Listed Building Consent for Alterations, Extension or Demolition of a Listed Building

Development: Listed building consent for the replacement of double glazed aluminum / timber windows and doors with double glazed painted timber casement, sprung sash windows and matching French doors.

Location: Little Welbourne Church Lane Pagham PO21 4NX

NORTH ELEVATION - BALCONY

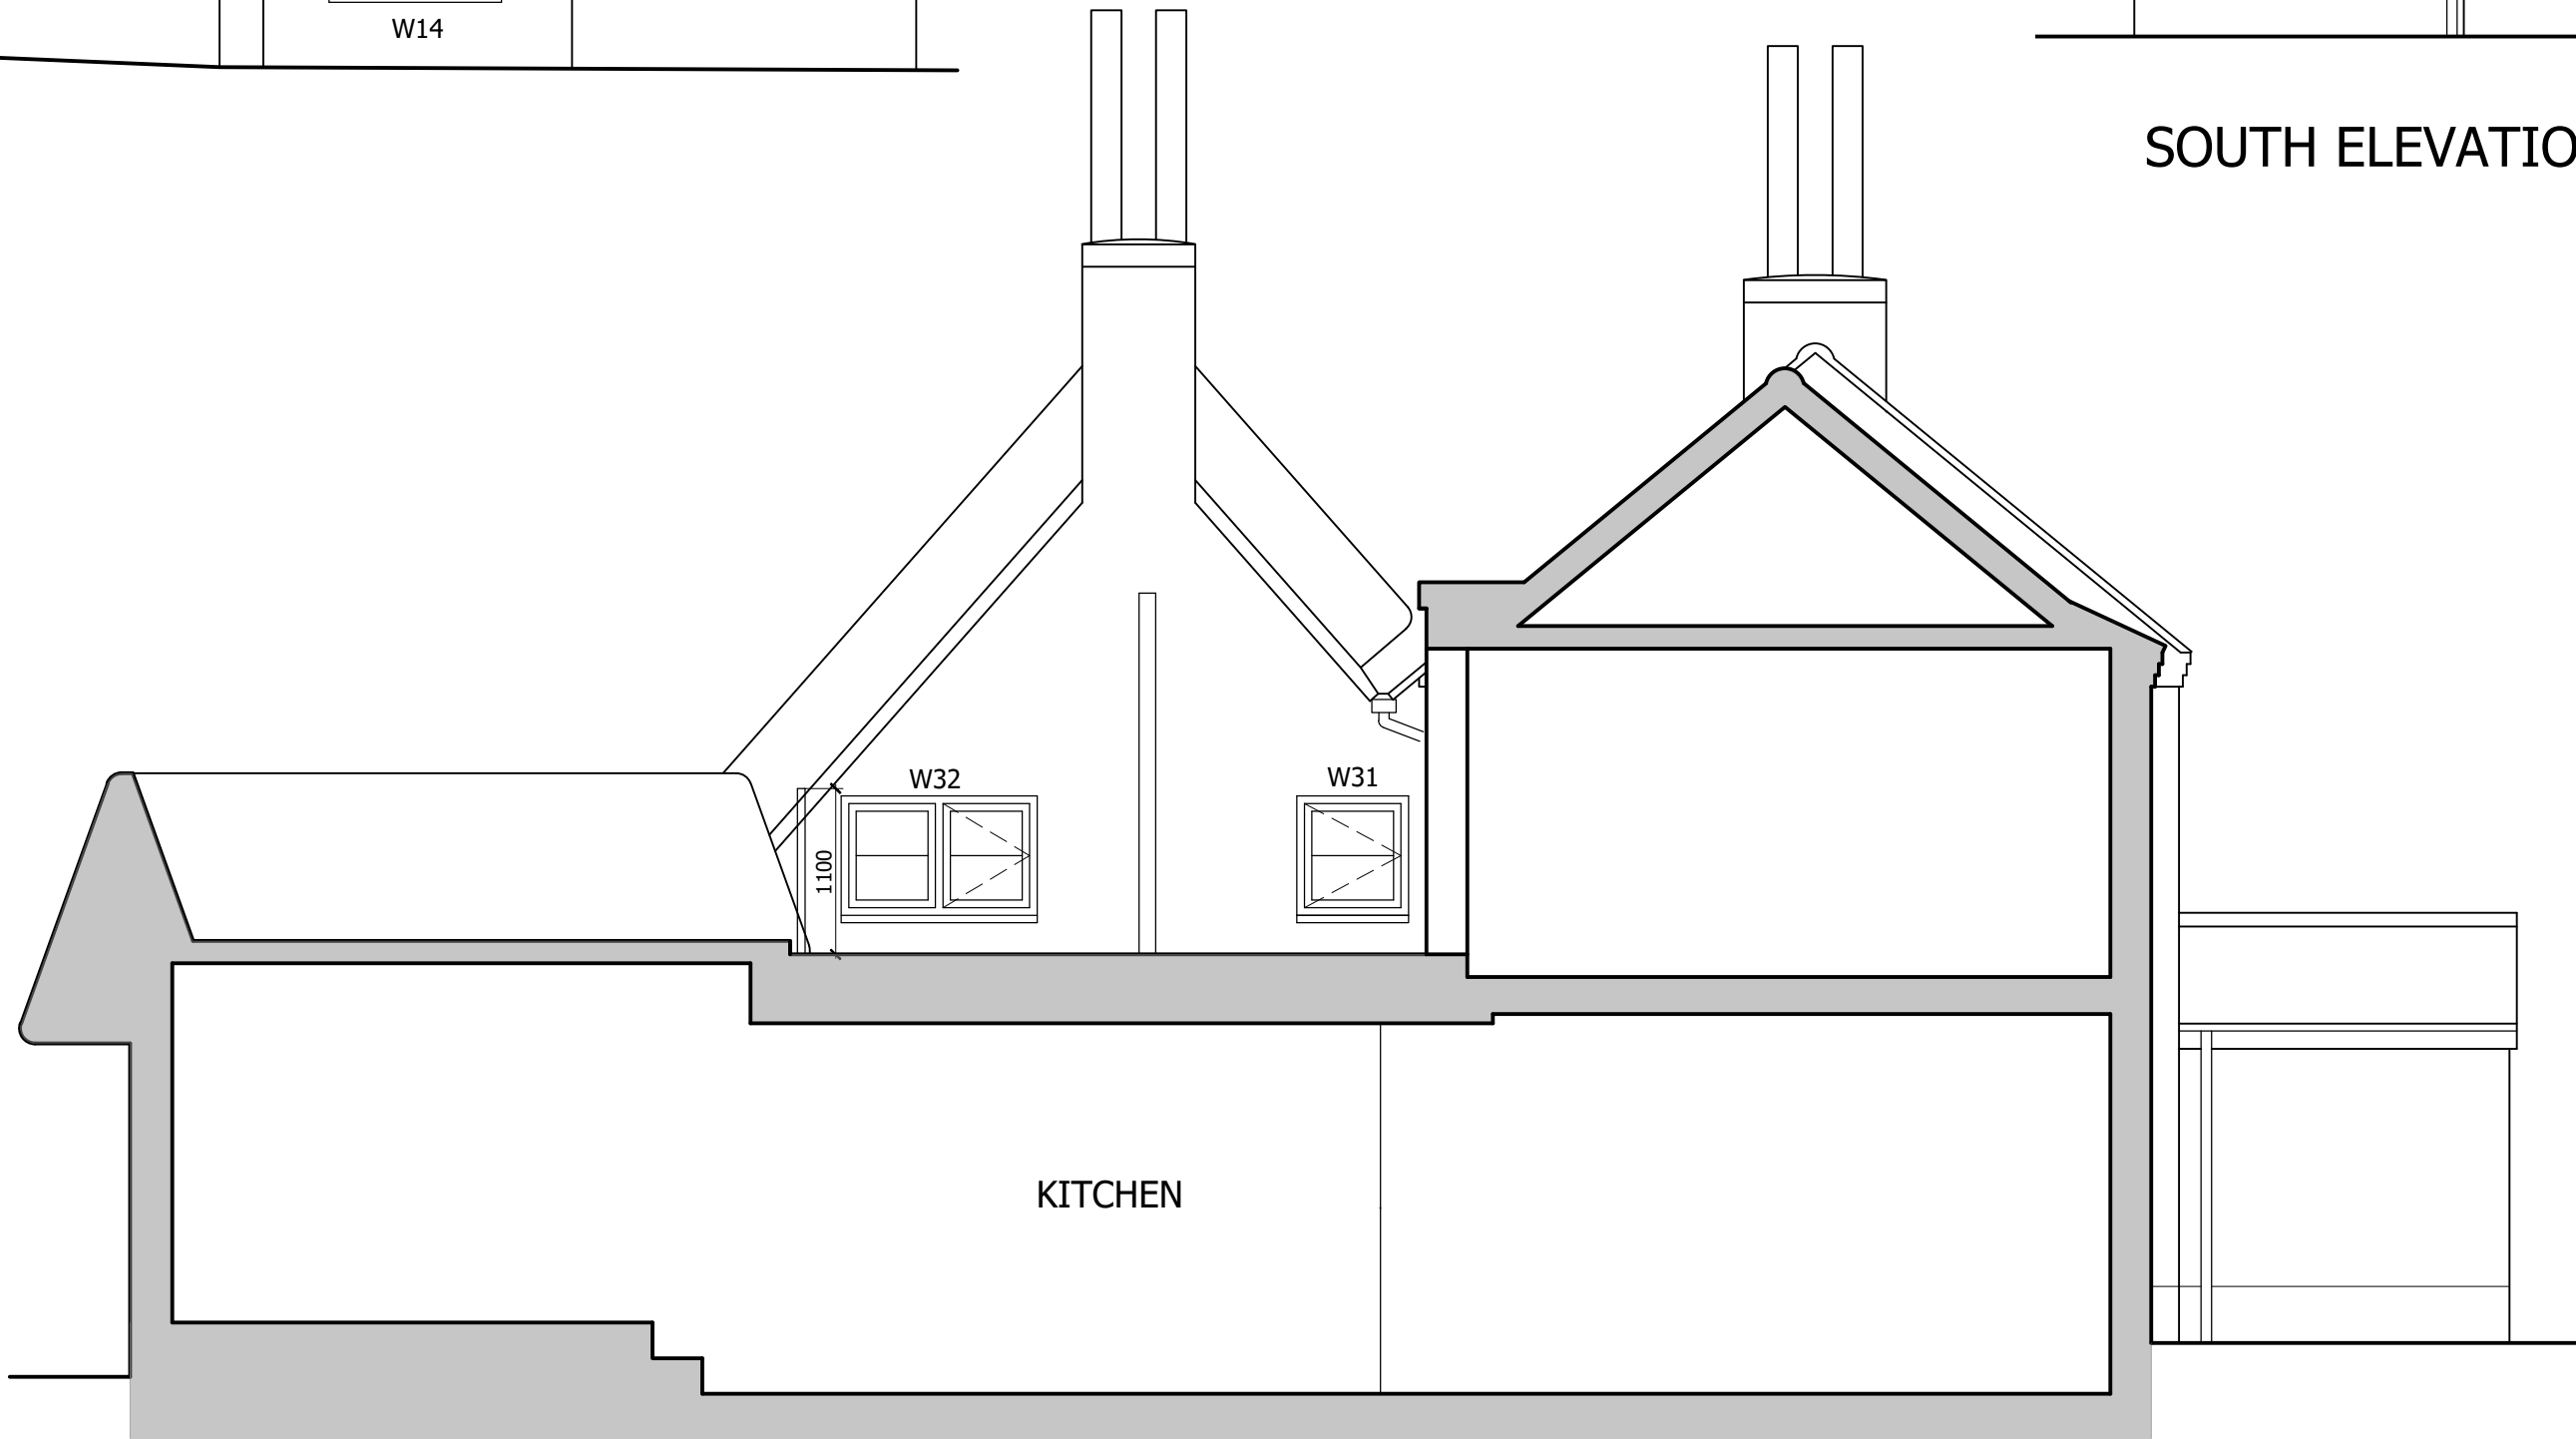
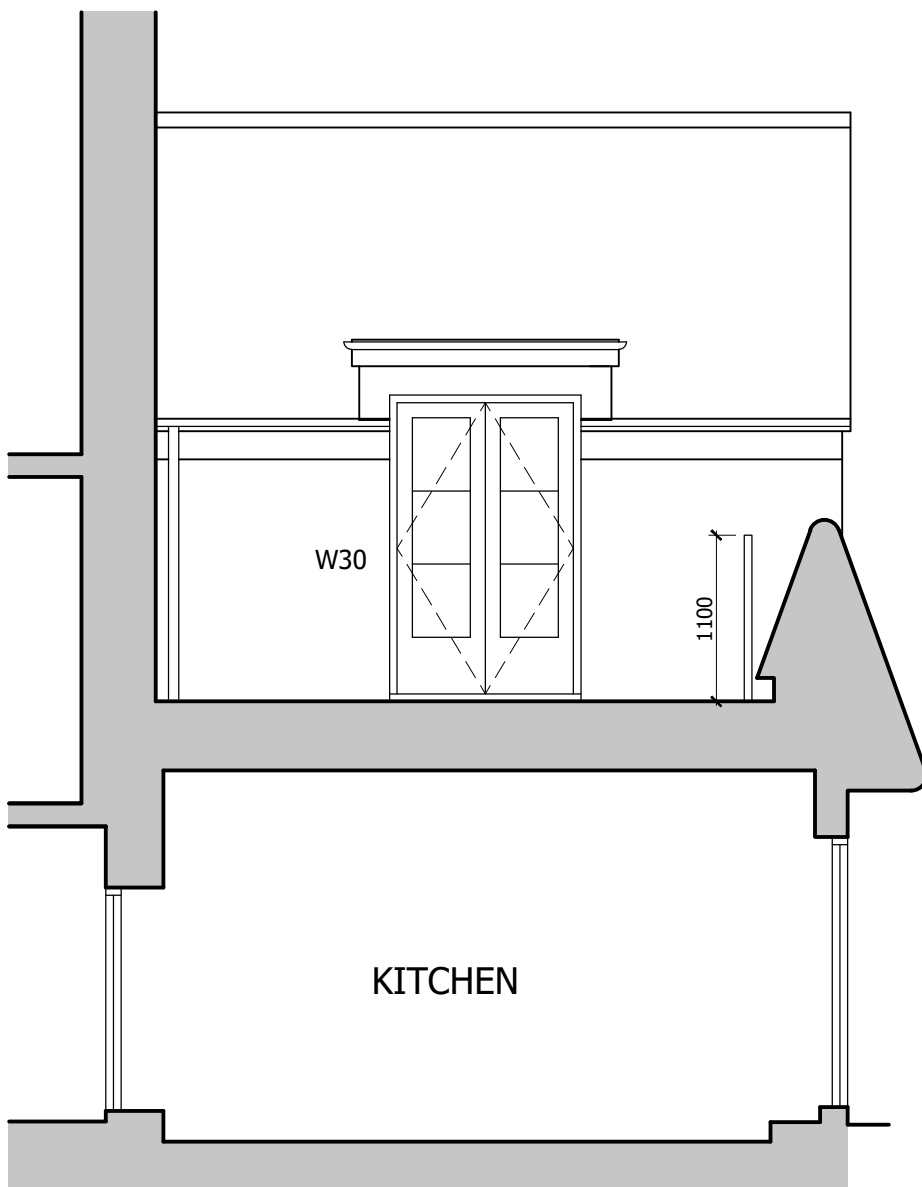
Please confirm if there will be internal changes, the existing and proposed sectional plans are inconsistent, if not then please clarify.
